Application for Planning Permission
Town and Country Planning Act 1990

Extension to muck store to provide fodder storage - see attached v. map

RE: Extension to muck store to provide fodder storage
 AT: Cragg House Farm, Chipping

Project Number, 230/201	Date, AUG/11	Scale, 1:100	By, JH
----------------------------	-----------------	-----------------	-----------

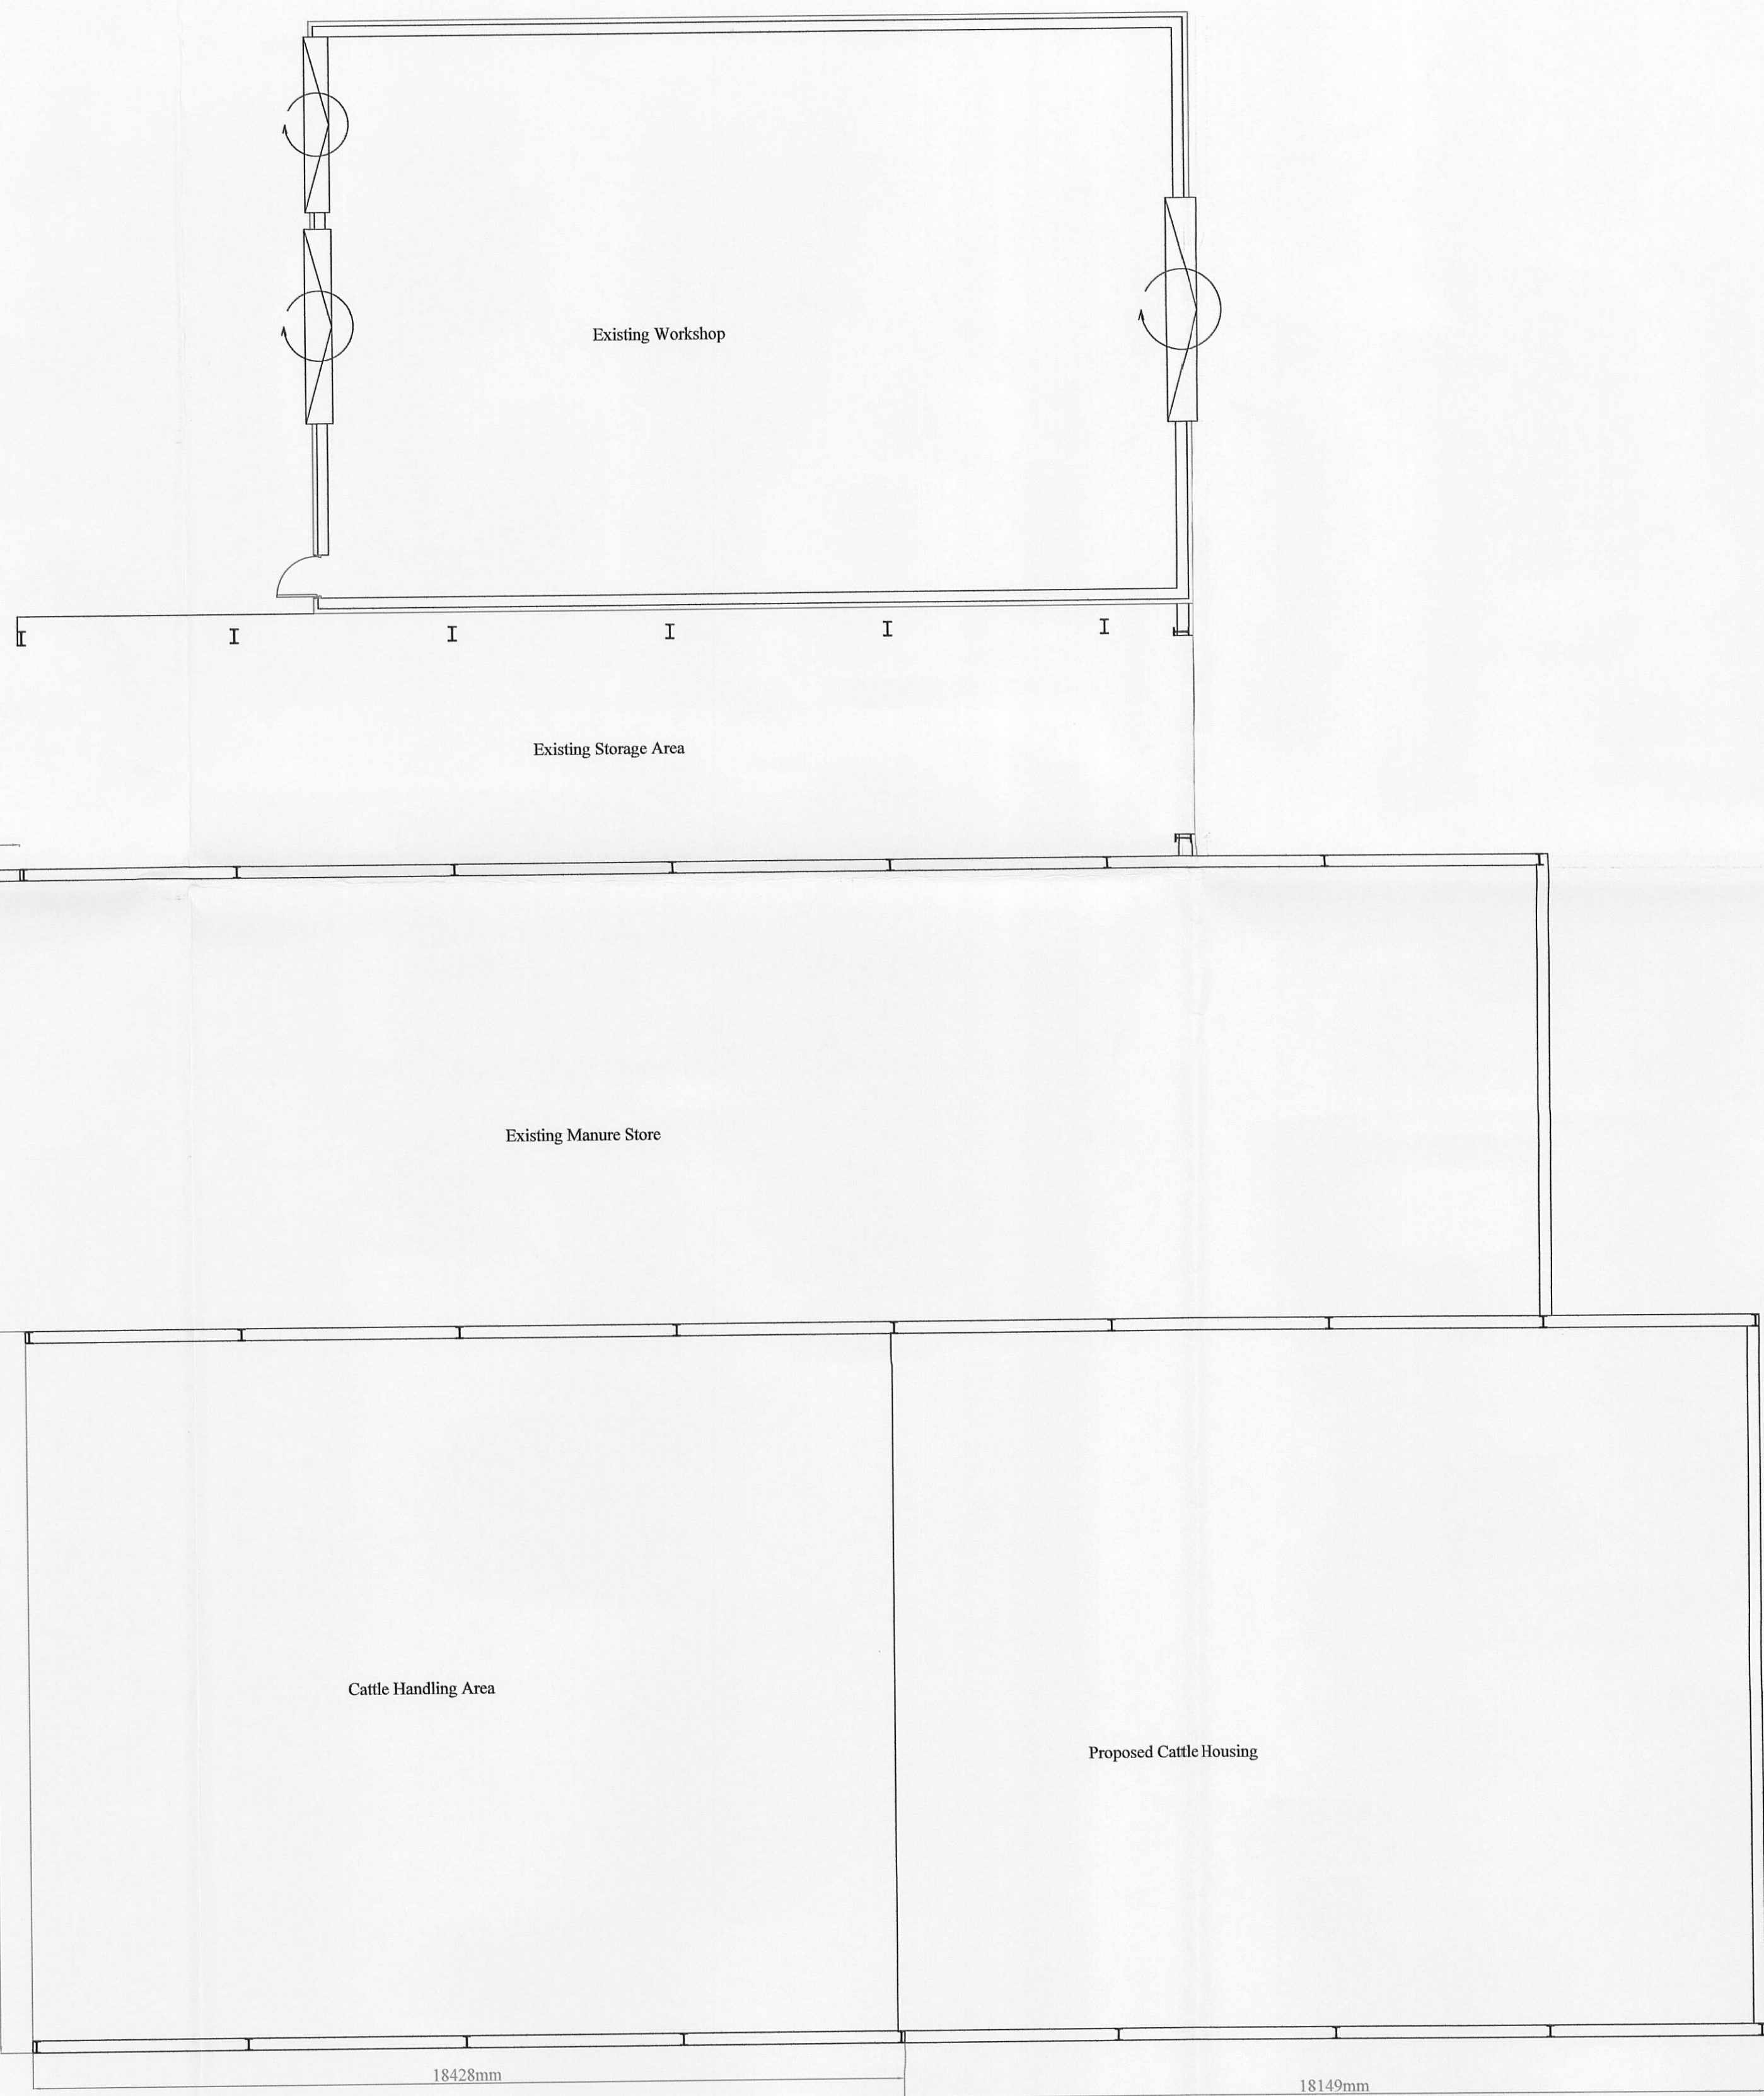
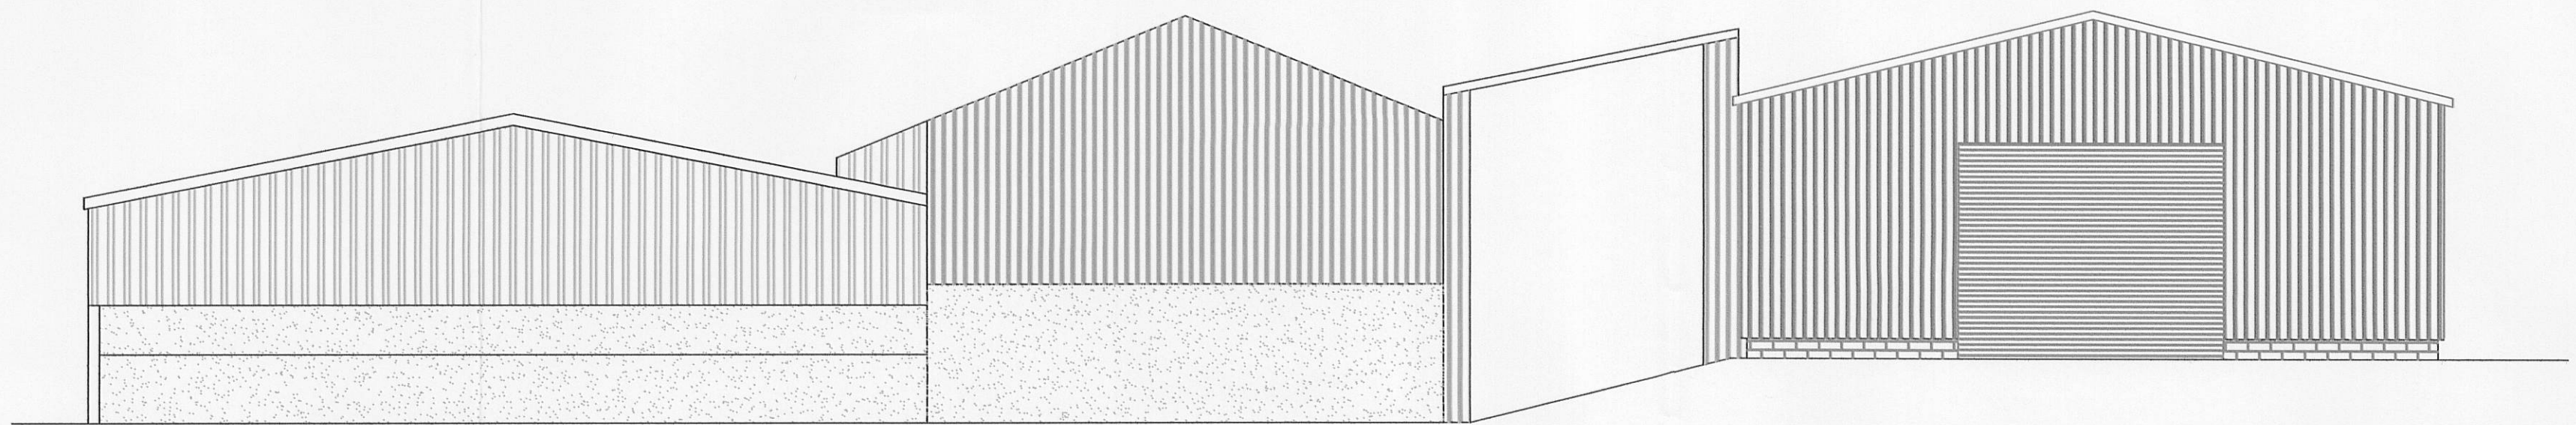
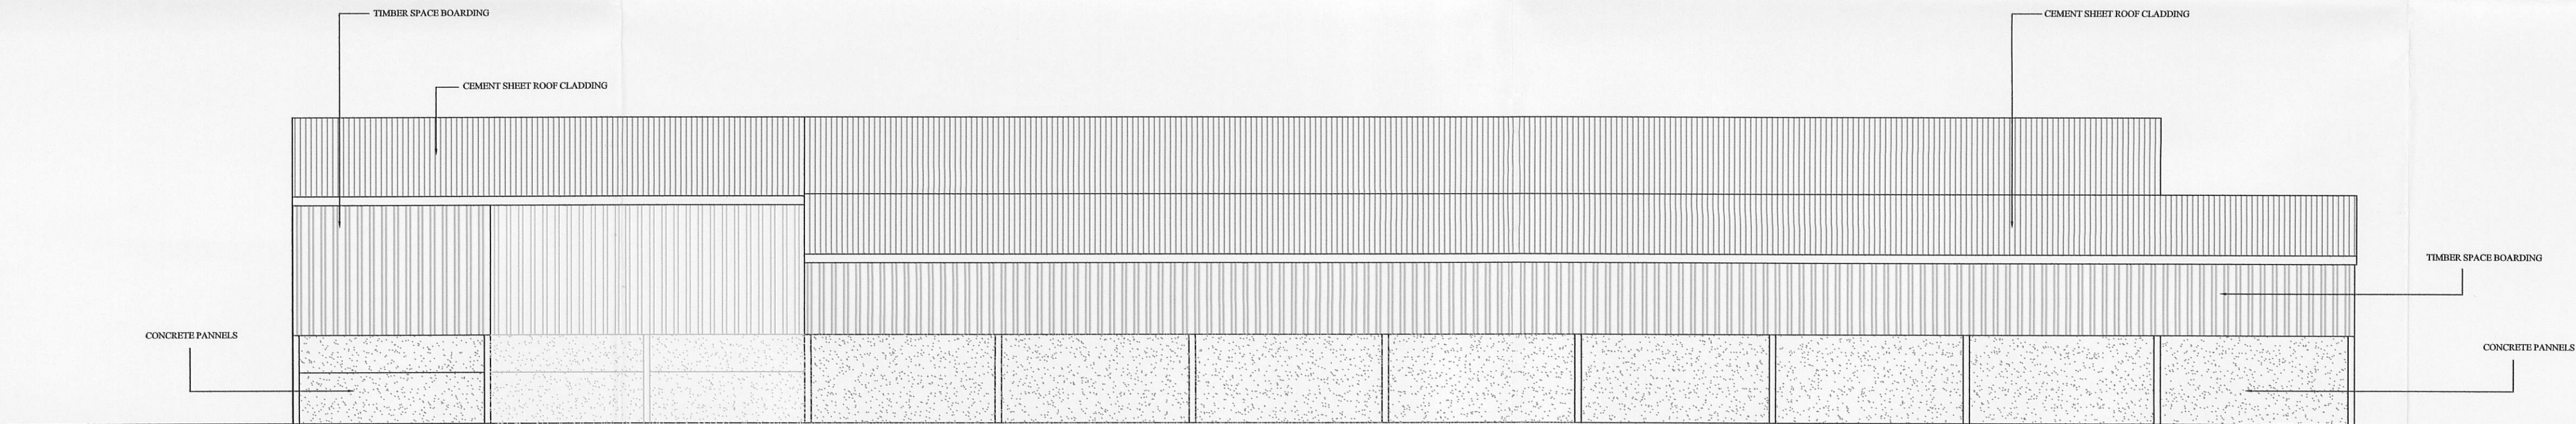
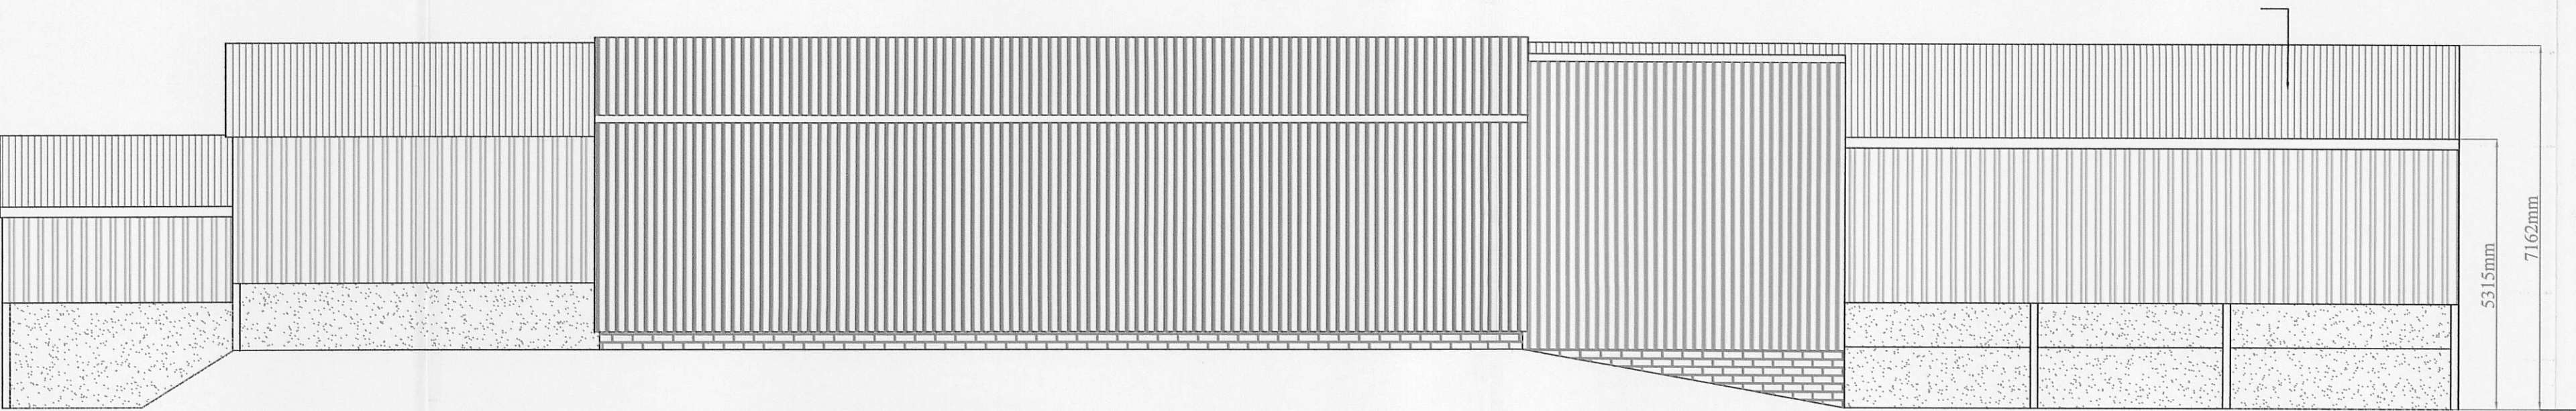
- I'm not sure that the floor plans and elevations match up properly - it might be easier if you could call into the offices and I'll show you where I think they don't match up ✓
